Build View
Unit 1A
50 Ferring Street
Ferring
BN12 5JP

Application for Planning Permission for Works or Extension to a Dwelling

Development: Erection of single storey side infill extension.
Location: Links Cottage Ham Manor Way Angmering BN16 4JQ

A 02

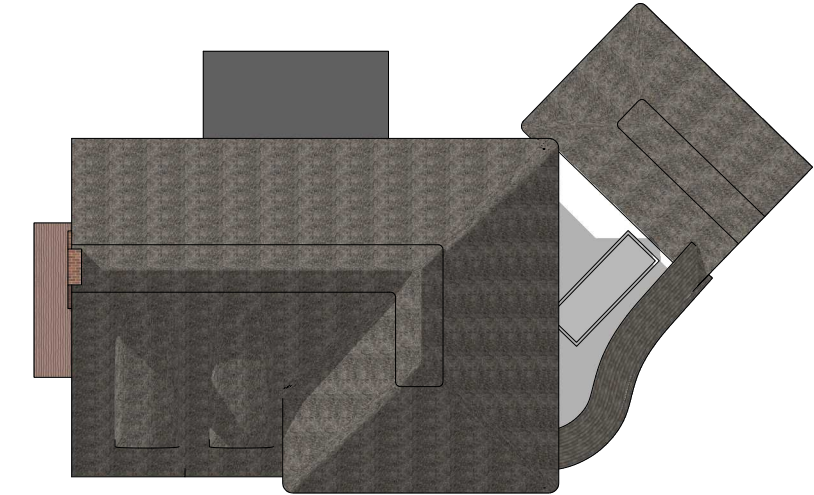
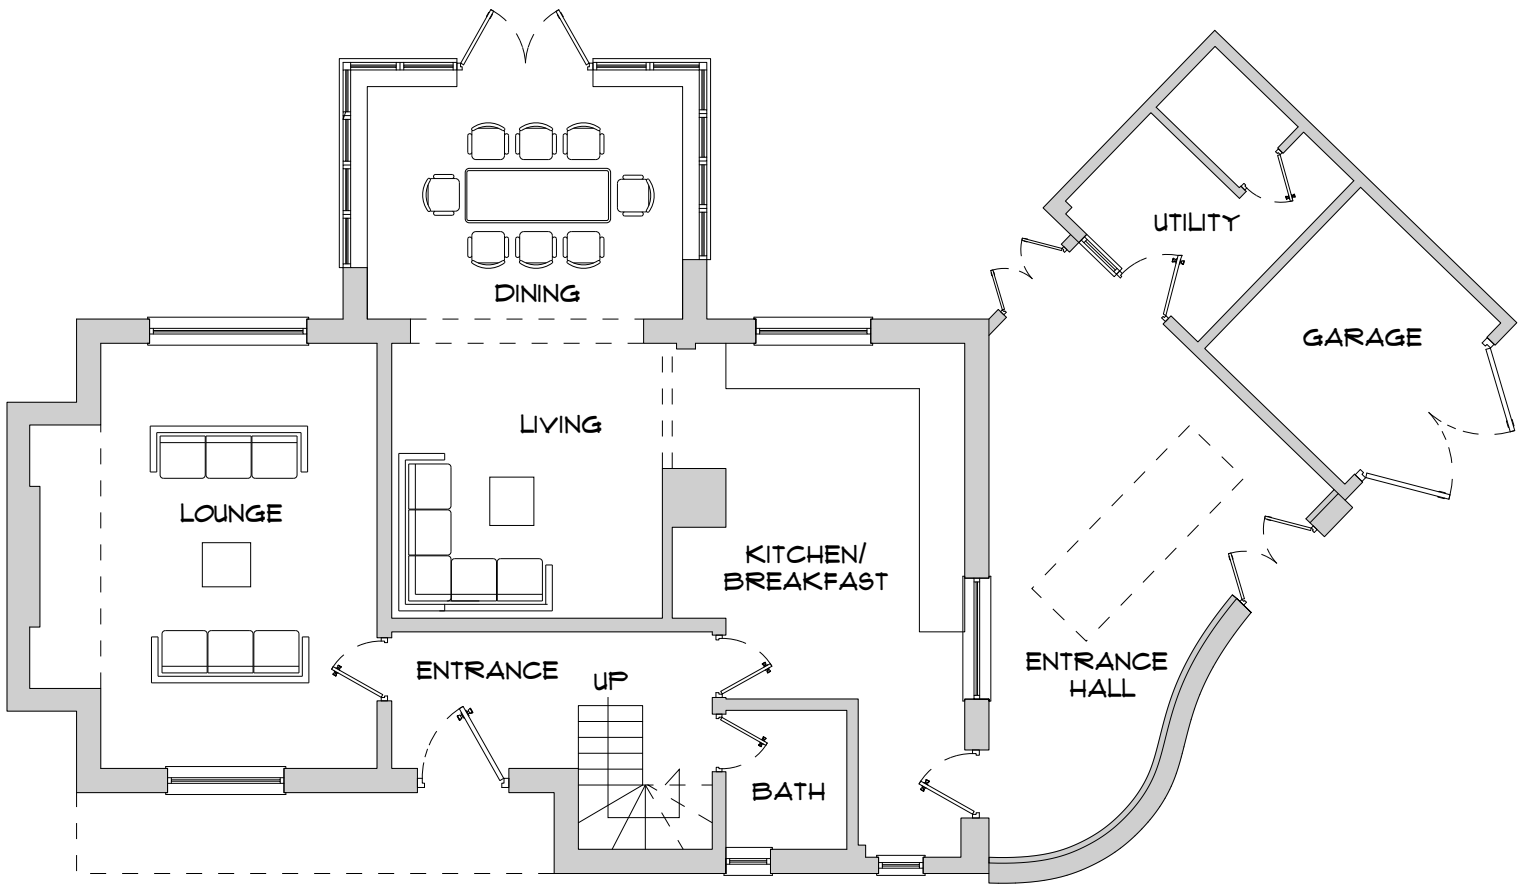
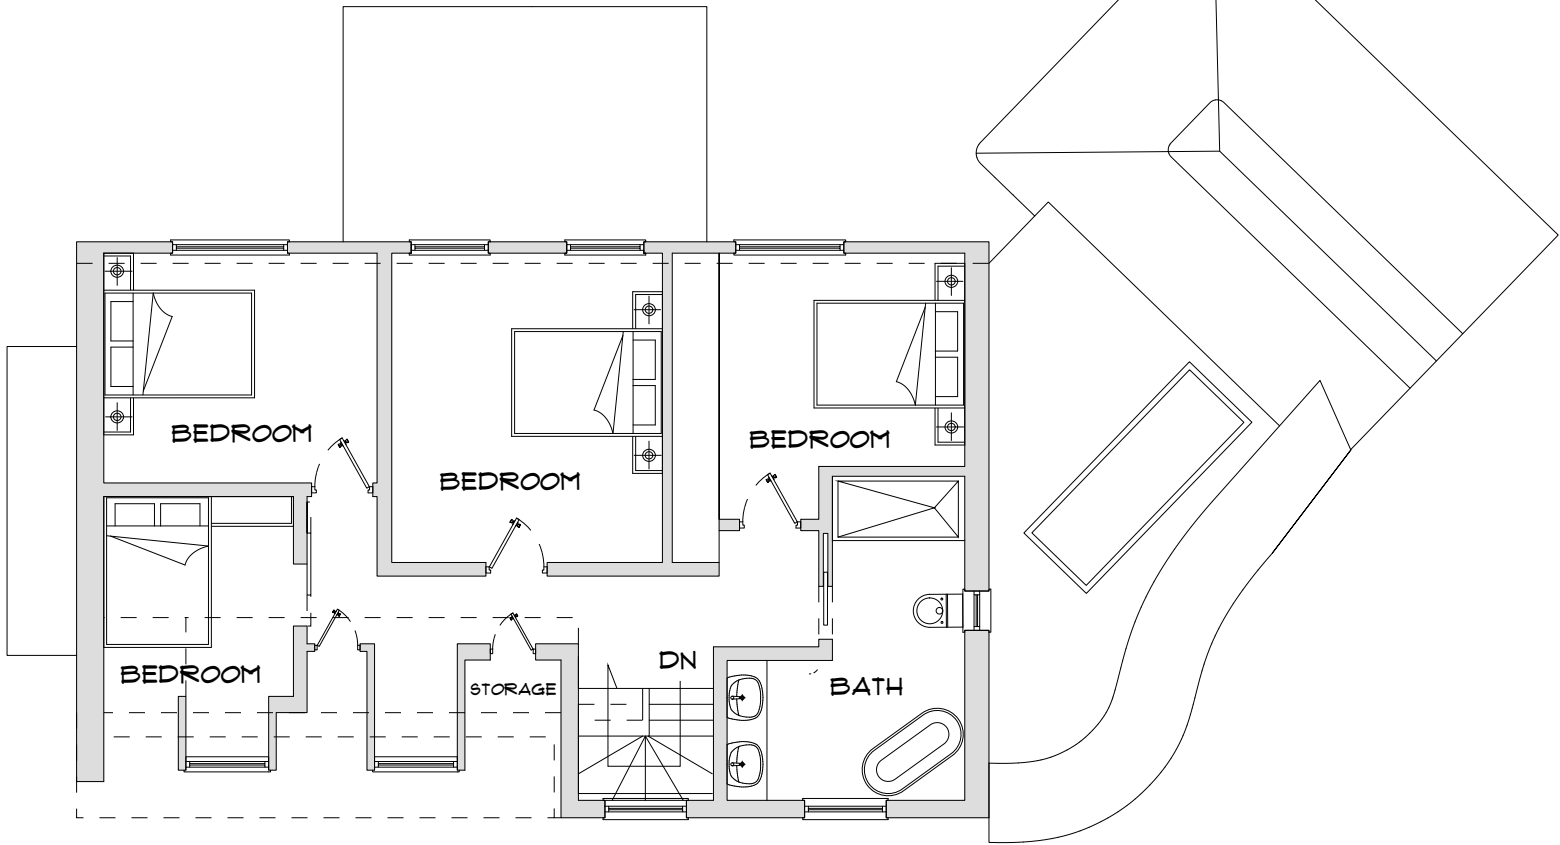
Proposed Floor Plans

The proposed floor/roof plans are labelled as existing. Please amend. Further details can be found in the Validation Requirements List.
